CITY OF ALBUQUERQUE  
PLANNING DEPARTMENT  
DEVELOPMENT REVIEW BOARD

**6. Project # 1002957**  
03DRB-01524 Major-Vacation of Public Easements  
03DRB-01525 Minor-Prelim&Final Plat Approval

JEFF MORTENSEN & ASSOCIATES, INC agent(s) for ALBUQUERQUE PUBLIC SCHOOLS request(s) the above action(s) for all or a portion of Tract(s) 26A-1, **TAYLOR RANCH**, zoned R-T, located on TAYLOR RANCH DR NW, between MONTANO RD NW and HOMESTEAD CIRCLE NW containing approximately 14 acre(s). [REF: DRB-91-133] (D-11)

VACATION REQUEST (RESUBMITTAL)
TRACT A, LYNDON B. JOHNSON MIDDLE SCHOOL
DRB PROJECT #1002957

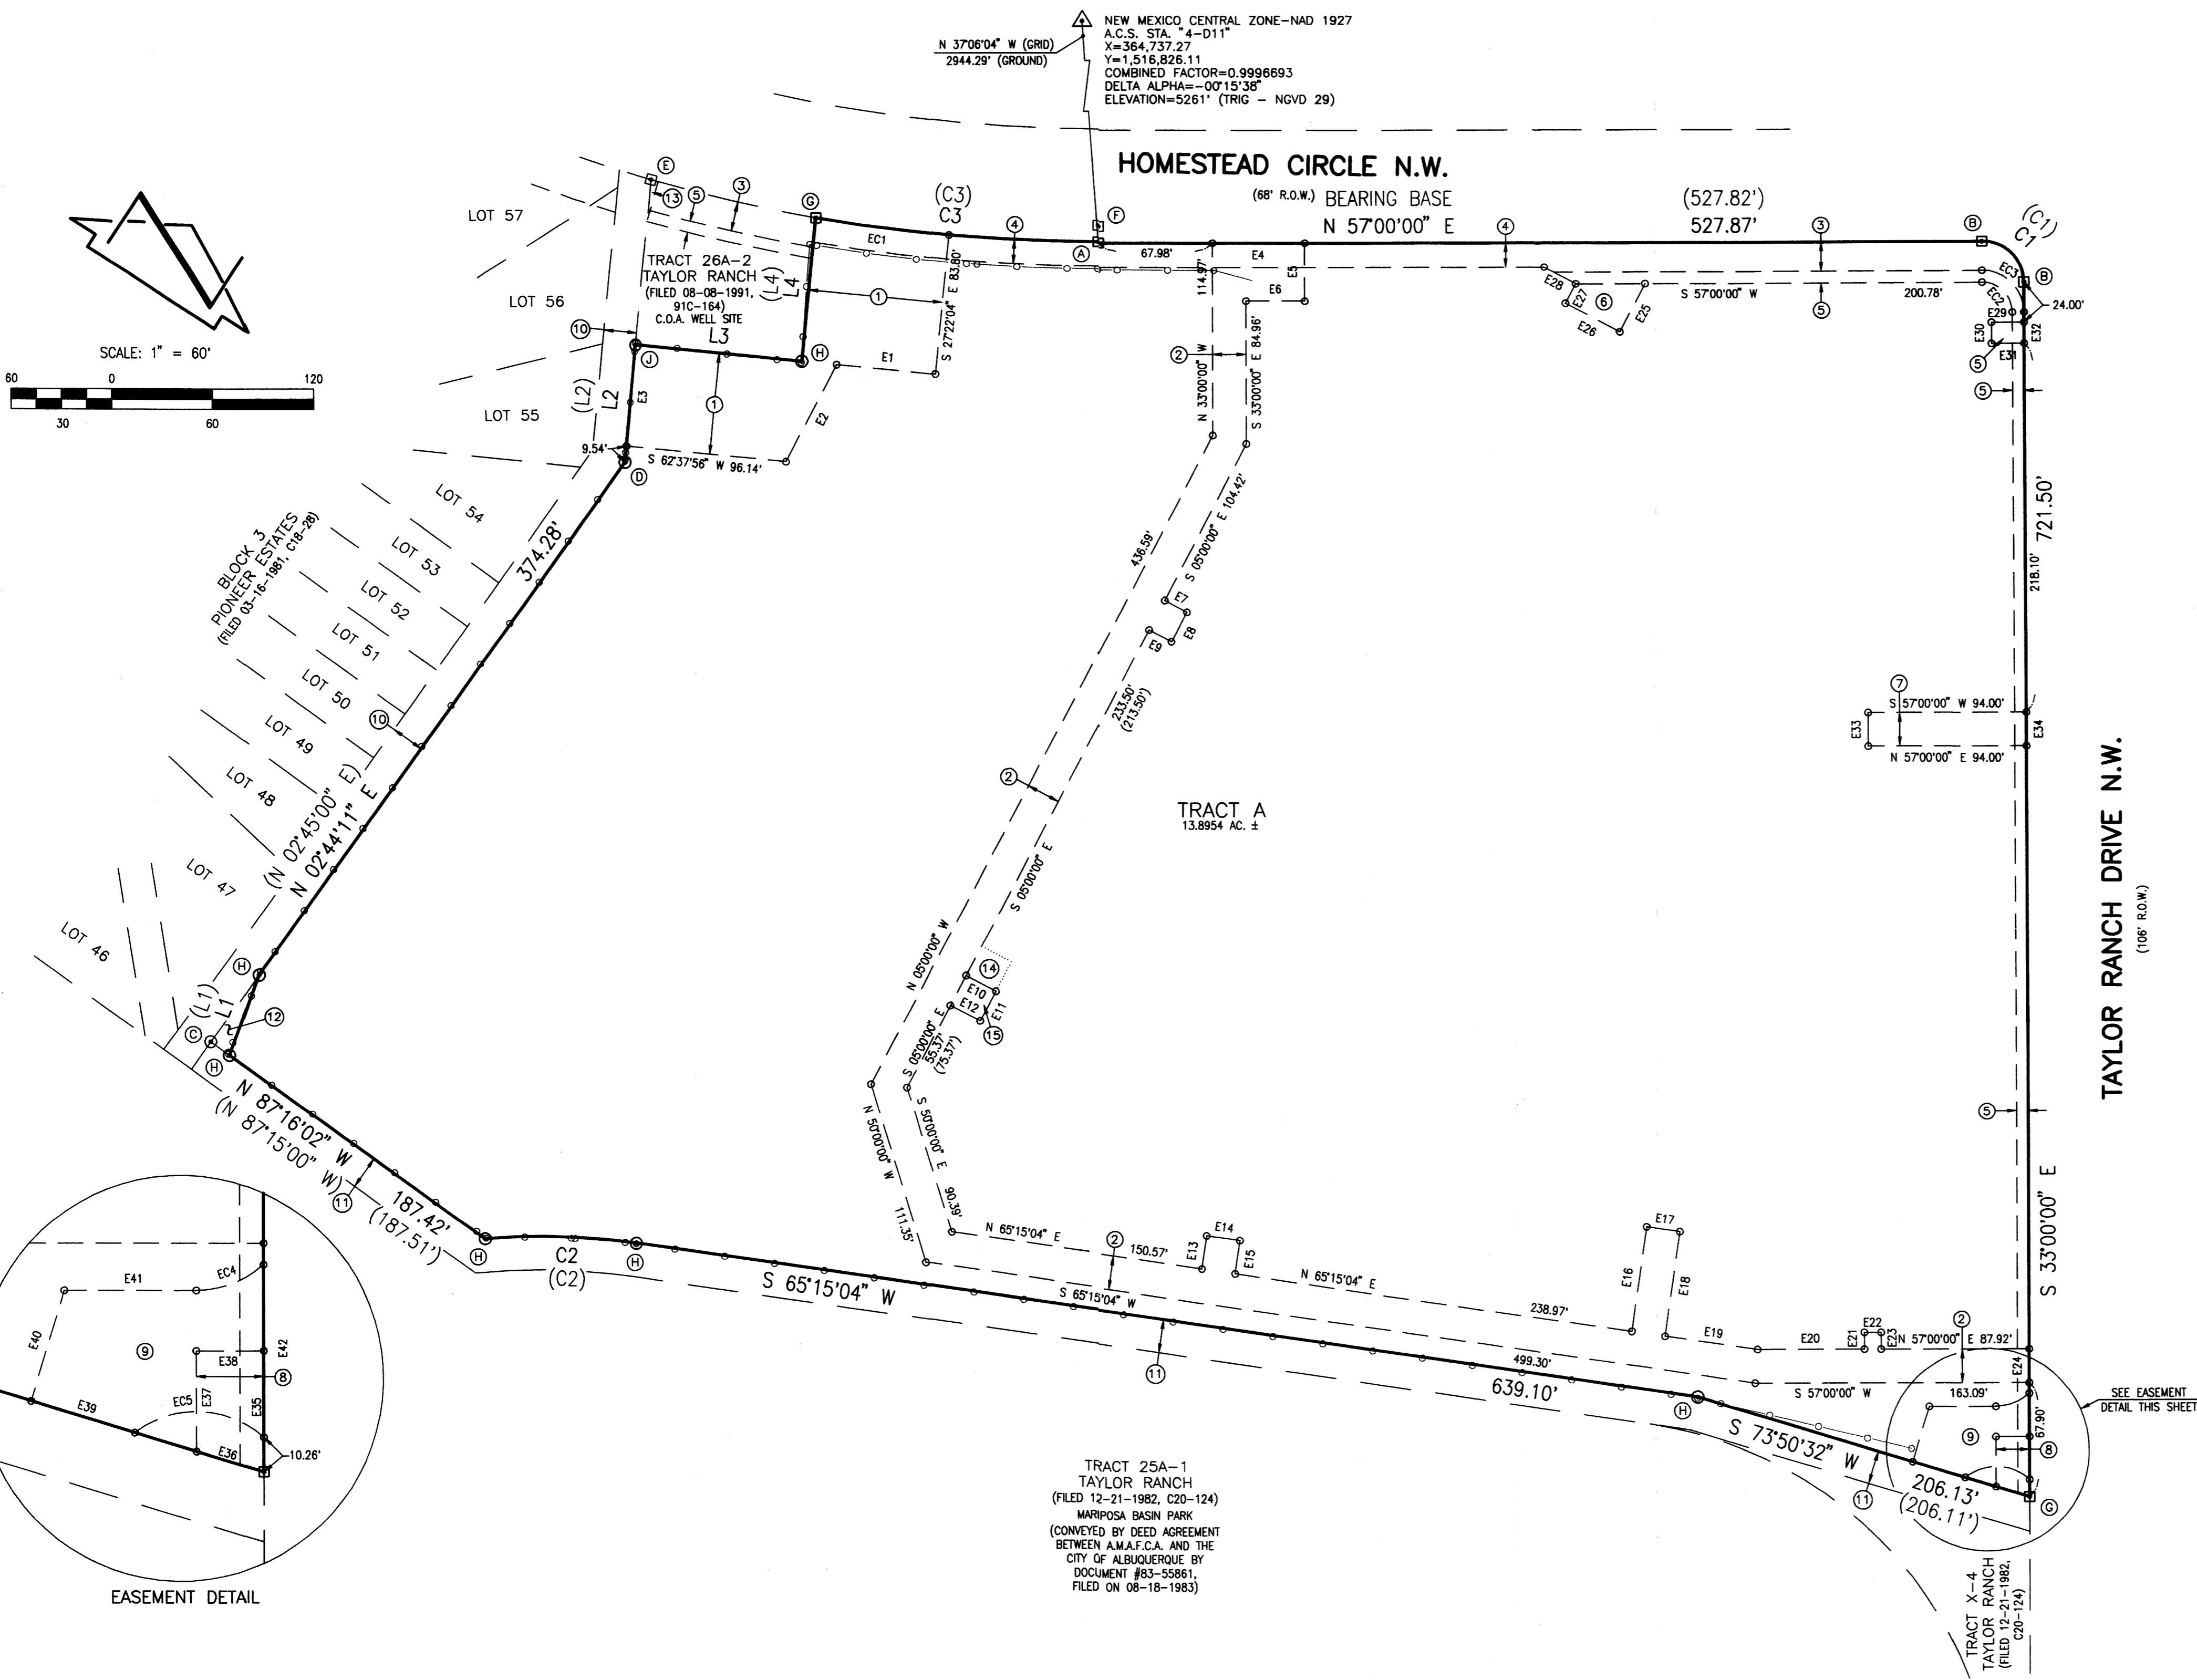
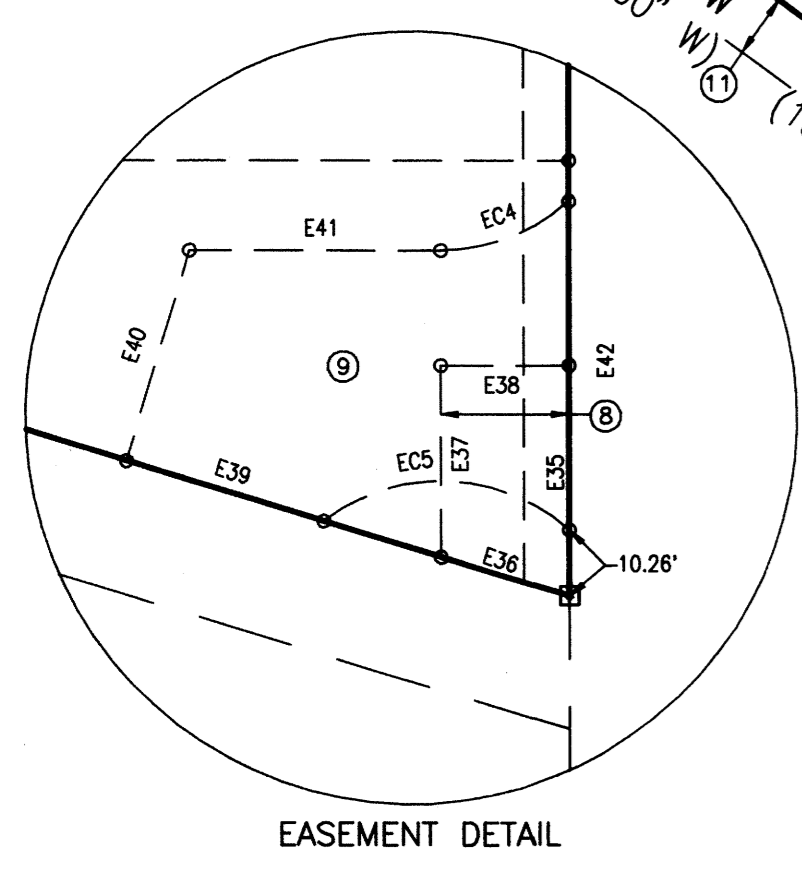
1. Prior to final plat approval a replacement temporary construction easement acceptable to the City's Water Utility Division and approved by the City Engineer shall be provided on the final plat.
2. The public welfare is in no way served by retaining the rights-of-way and/or easements, or:
3. There is a net benefit to the public welfare because the development made possible by the vacation is clearly more beneficial to the public welfare than the minor detriment resulting from the vacation.
4. There is no convincing evidence that any substantial property right is being abridged against the will of the owner of the right.
5. Final disposition shall be through the City Real Estate Office.
6. The vacated property shall be shown on a replat approved by the Development Review Board and the approved replat shall be filed for record with the Bernalillo County Clerk's Office within one year.

VACATION AND PLAT OF TRACT A, LYNDON B. JOHNSON MIDDLE SCHOOL

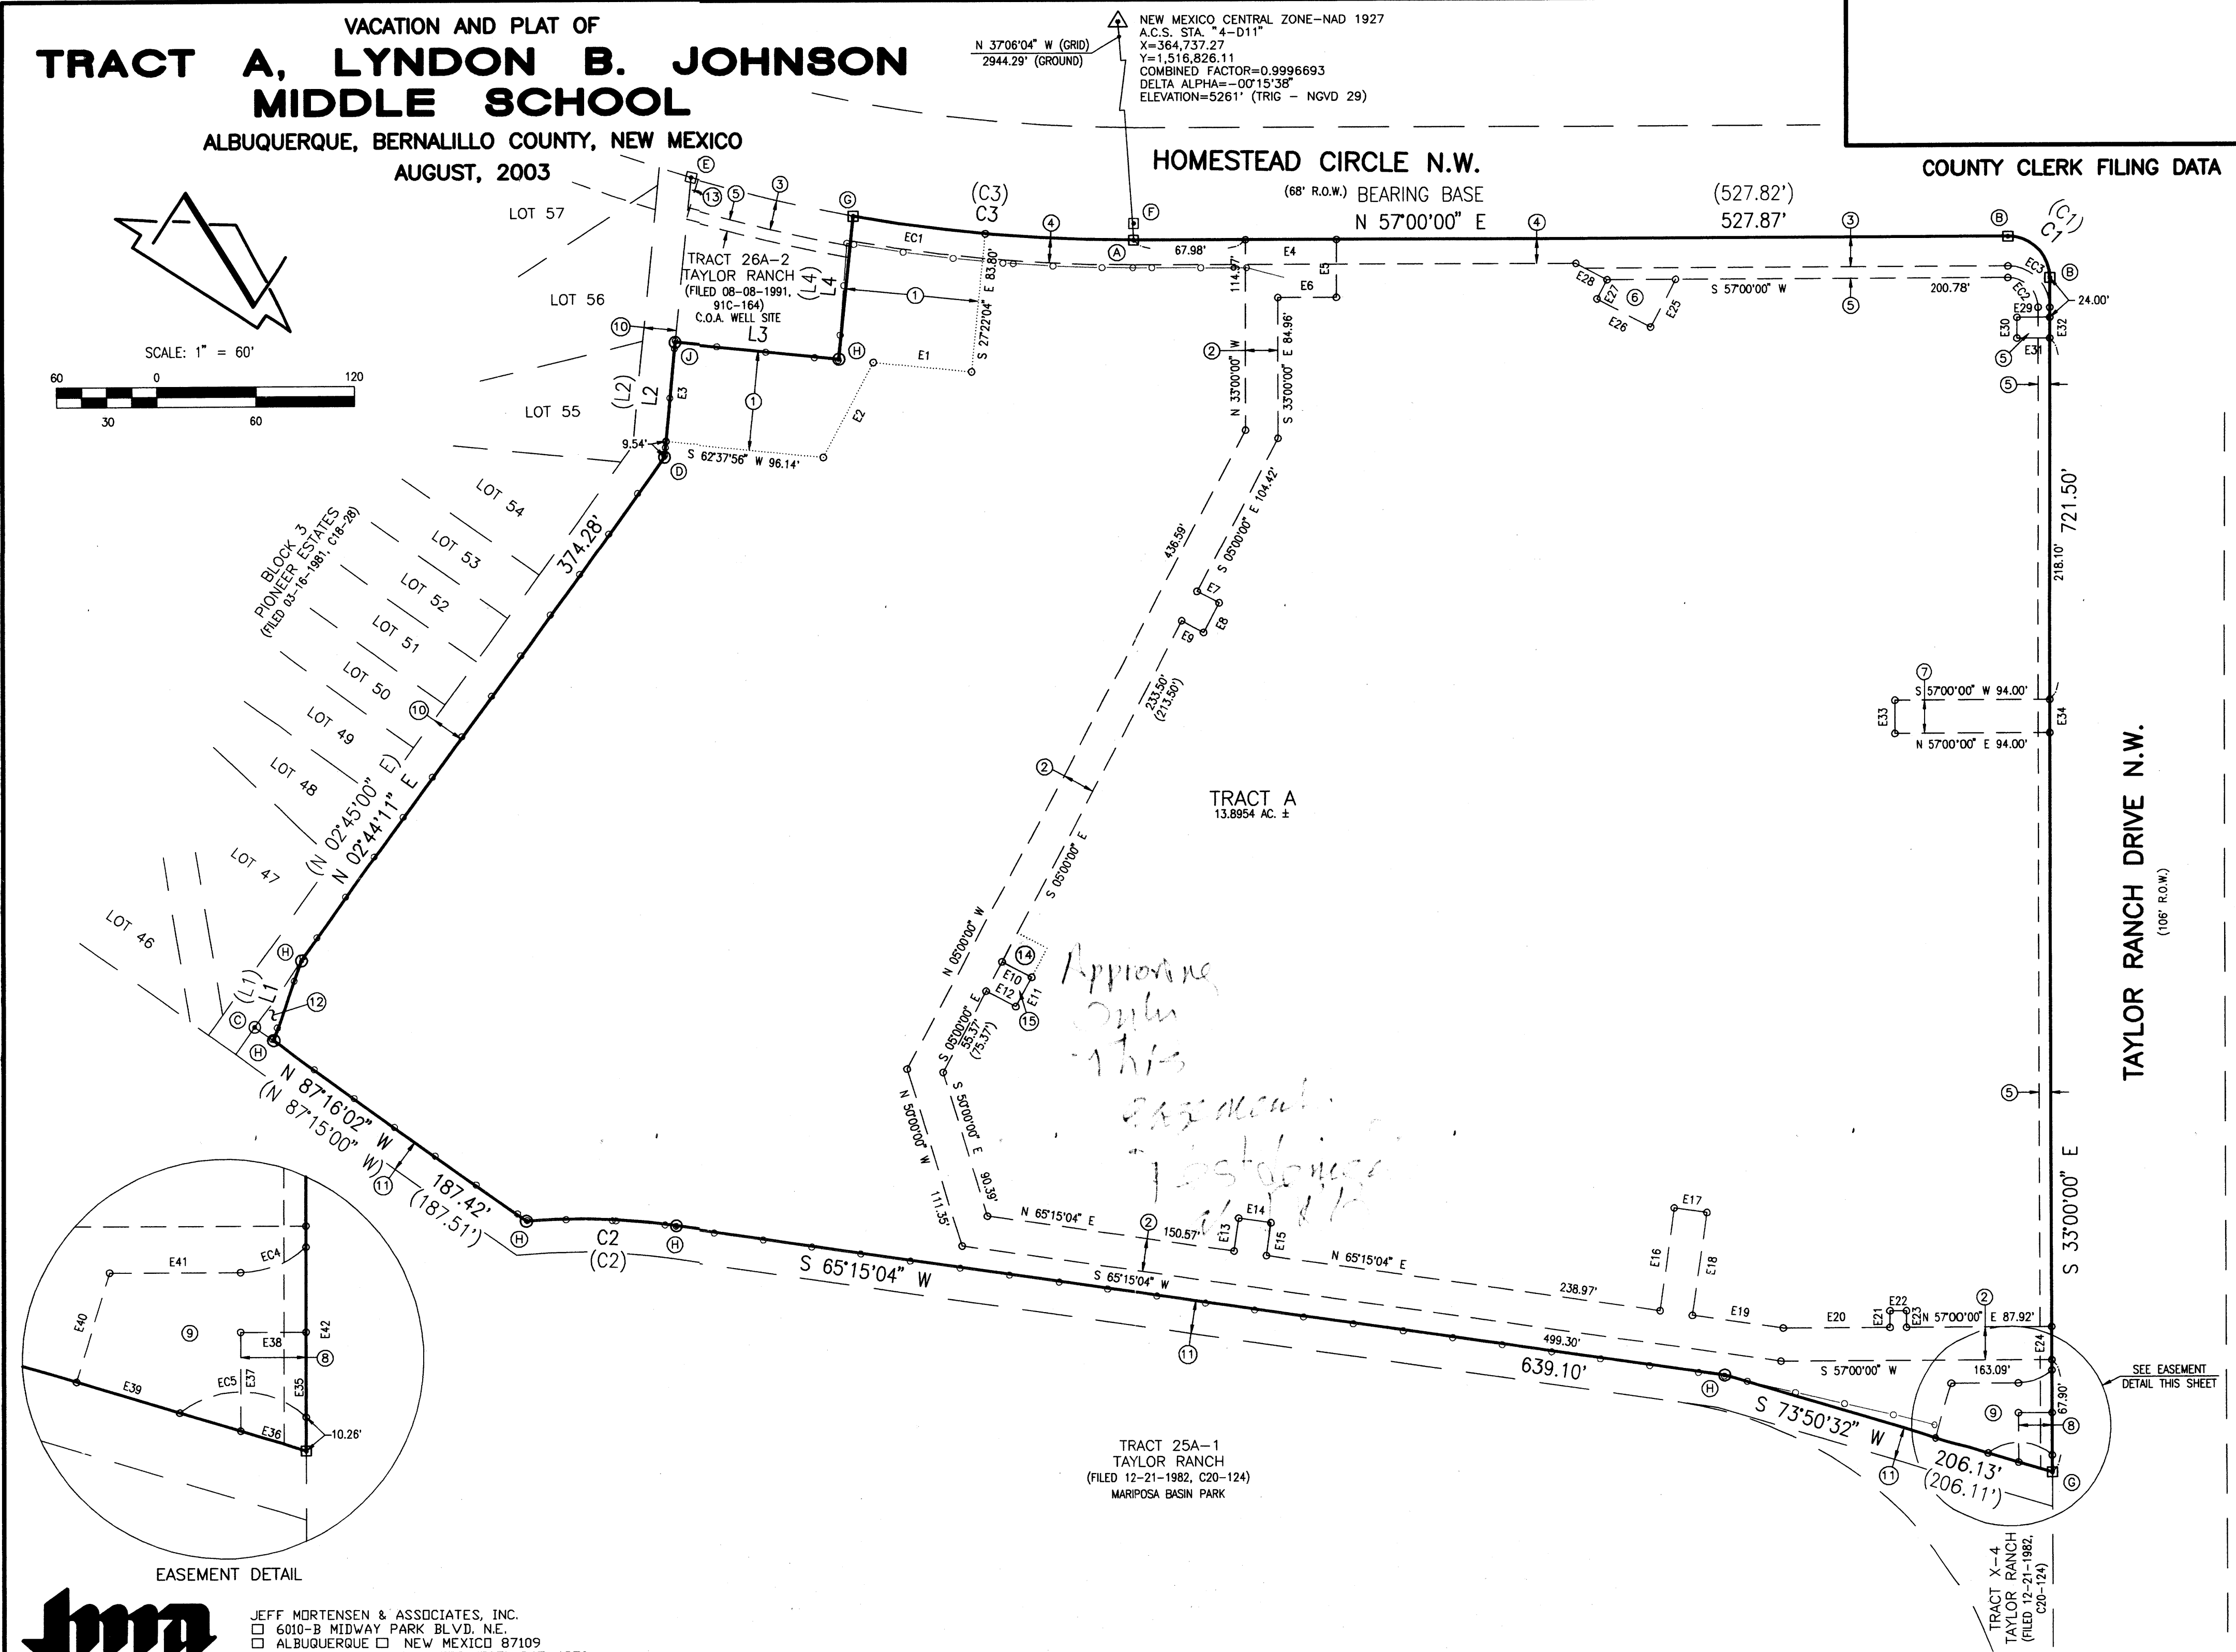
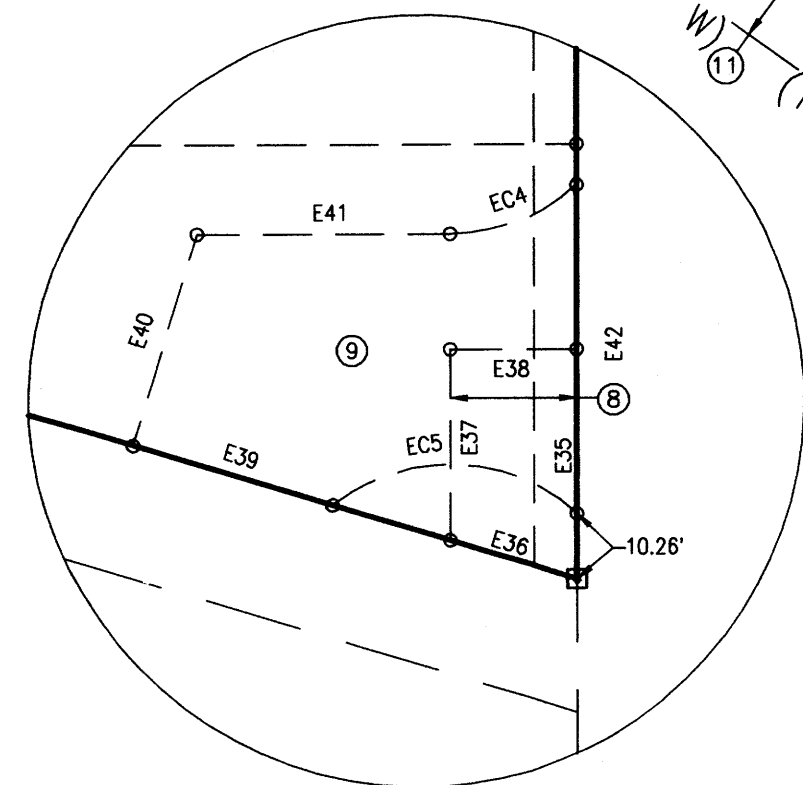
The preliminary plat was approved with final sign off delegated to Utilities Development to check for removal of vacation (1) on sheets 2 of 3 of the plat and to Planning for AGIS DXF file.
